Re: Planning Application 19/1031 and 1032

Address: Plots 1 and 2, 8 Hammond Drive Read BB12 7RE

Description: Proposed two-story dwelling house with integral garage, parking and drive access.

Plot 1
Site Layout & Sections

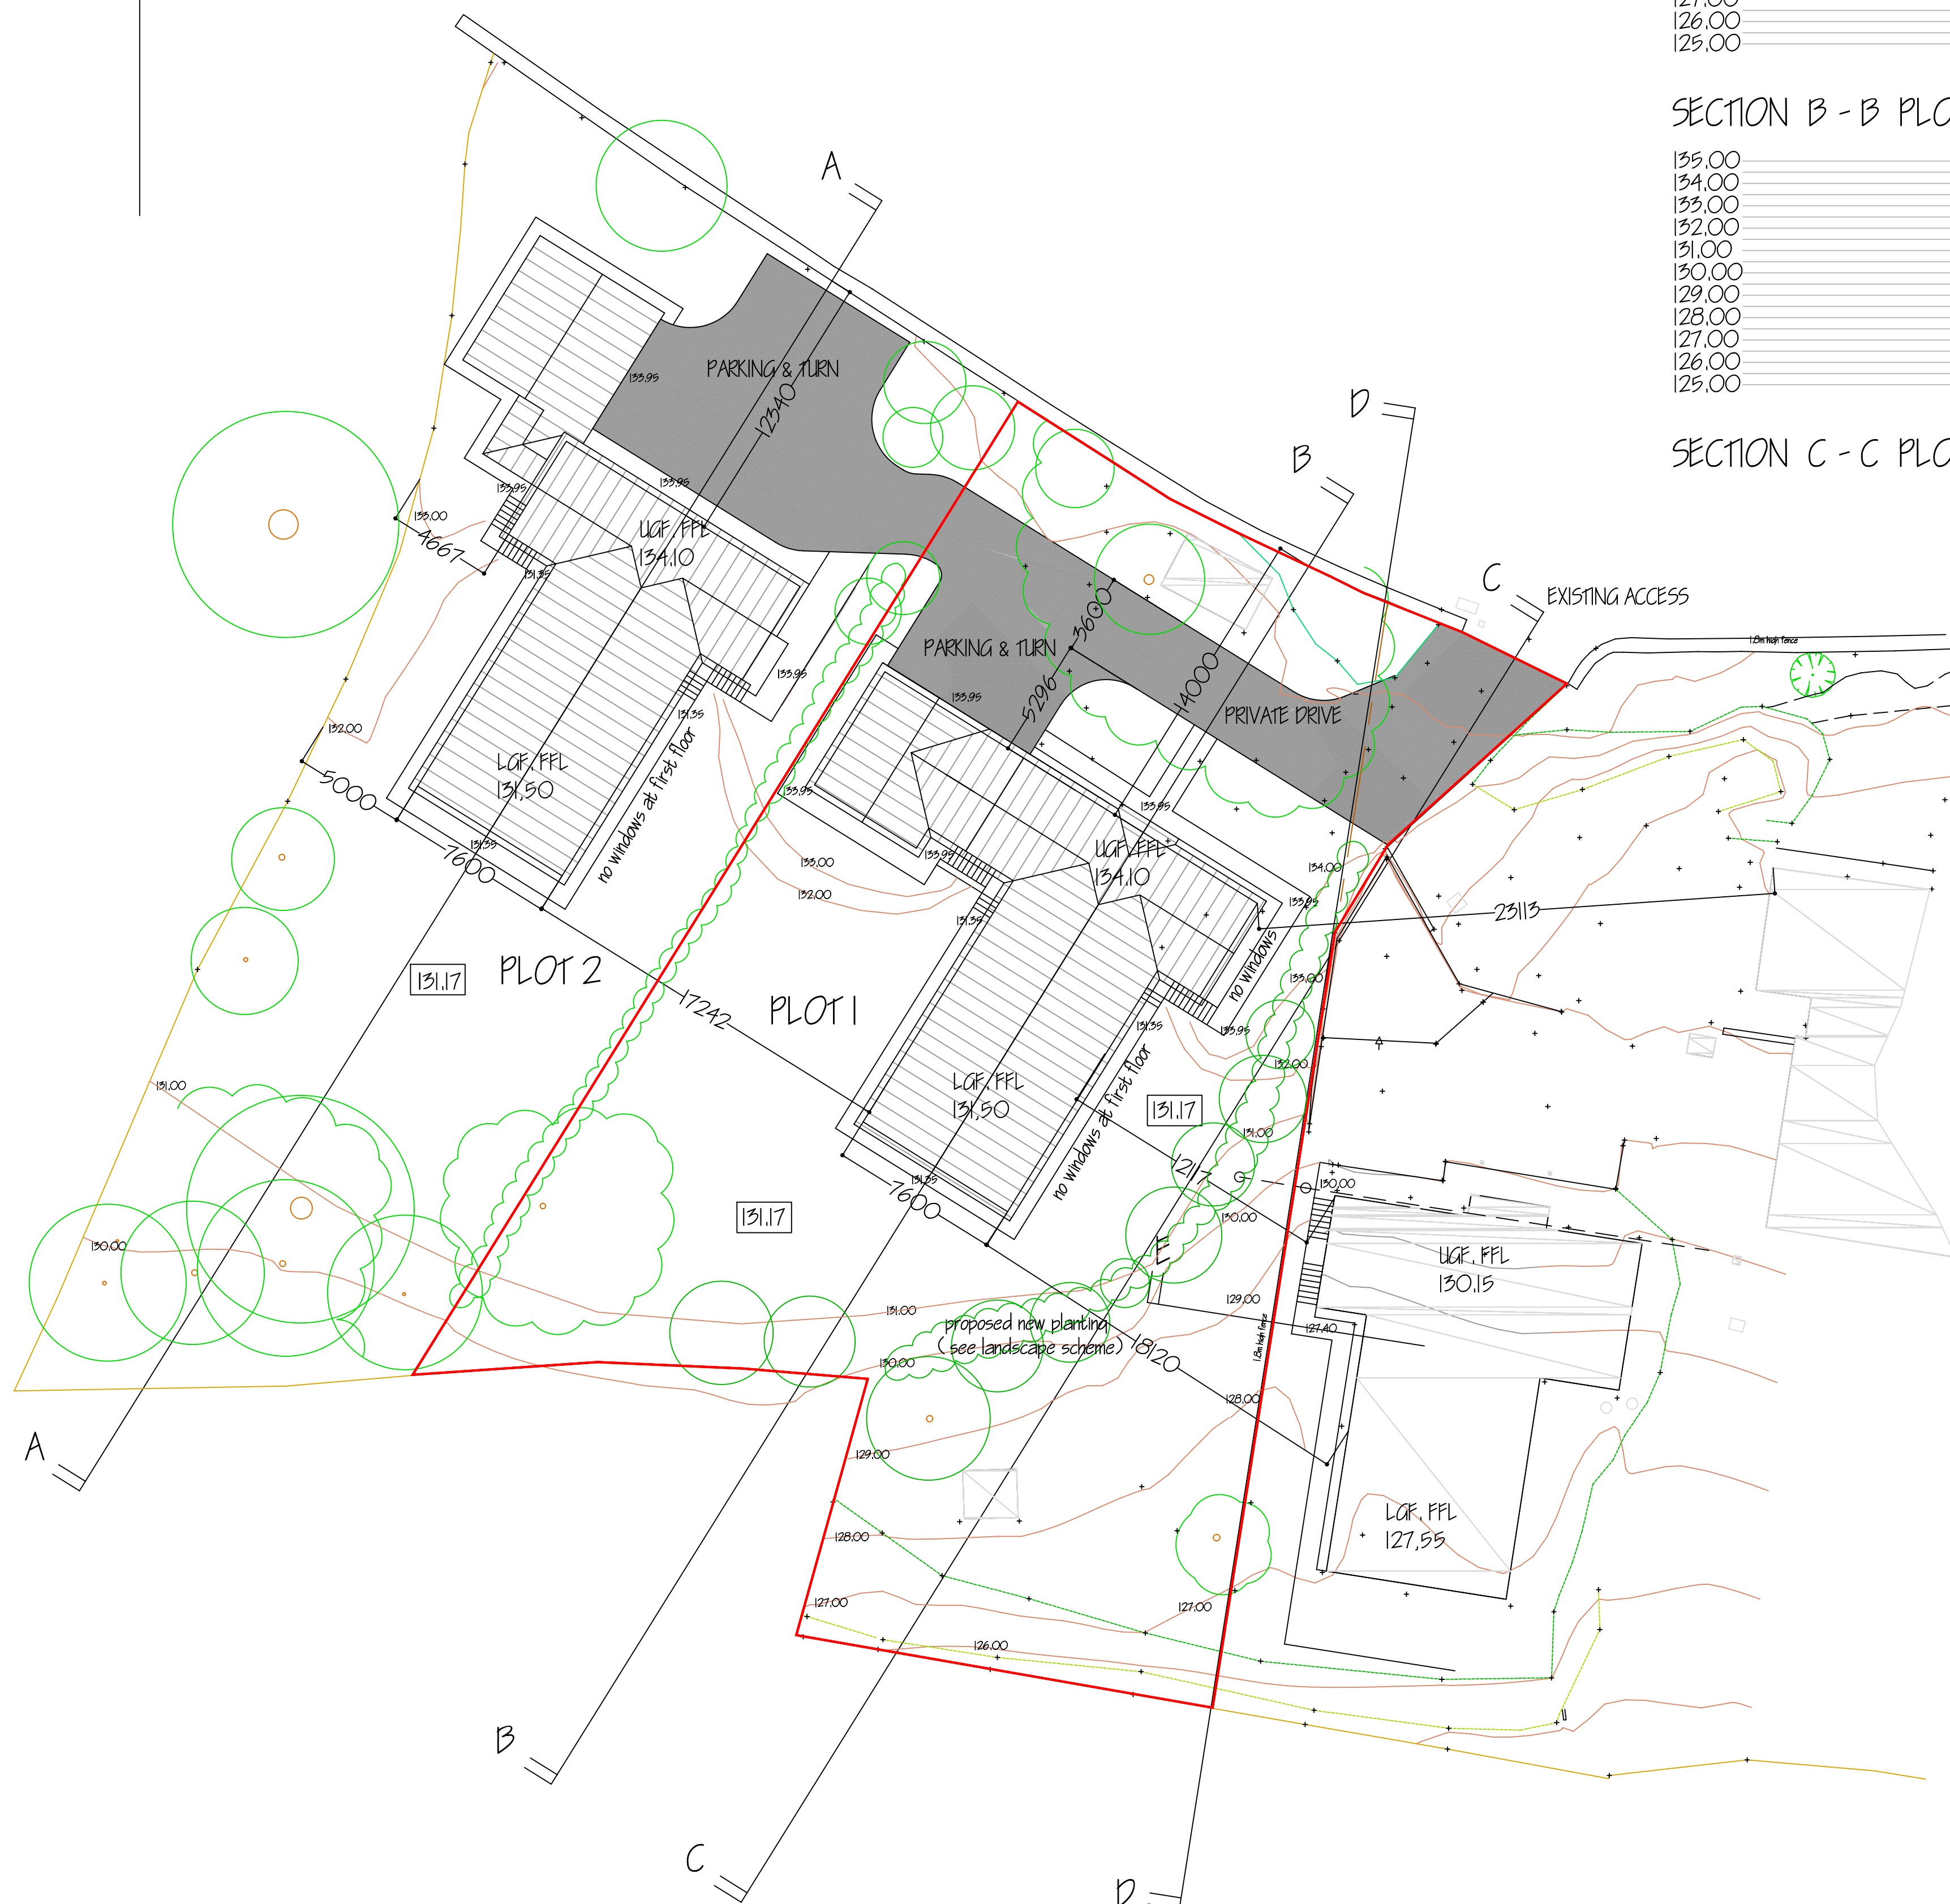
A further plan has been submitted No 1945/2/003 Rev B showing the widened drive with the swept paths showing the access arrangements are viable.

1. Before the access is used for vehicular purposes, that part of the access extending from the highway boundary for a minimum distance of 5m into the site shall be appropriately paved in tarmacadam, concrete, block pavements, or other approved materials. **Reasons:** To prevent loose surface material from being carried on to the public highway thus causing a potential source of danger to other road users.
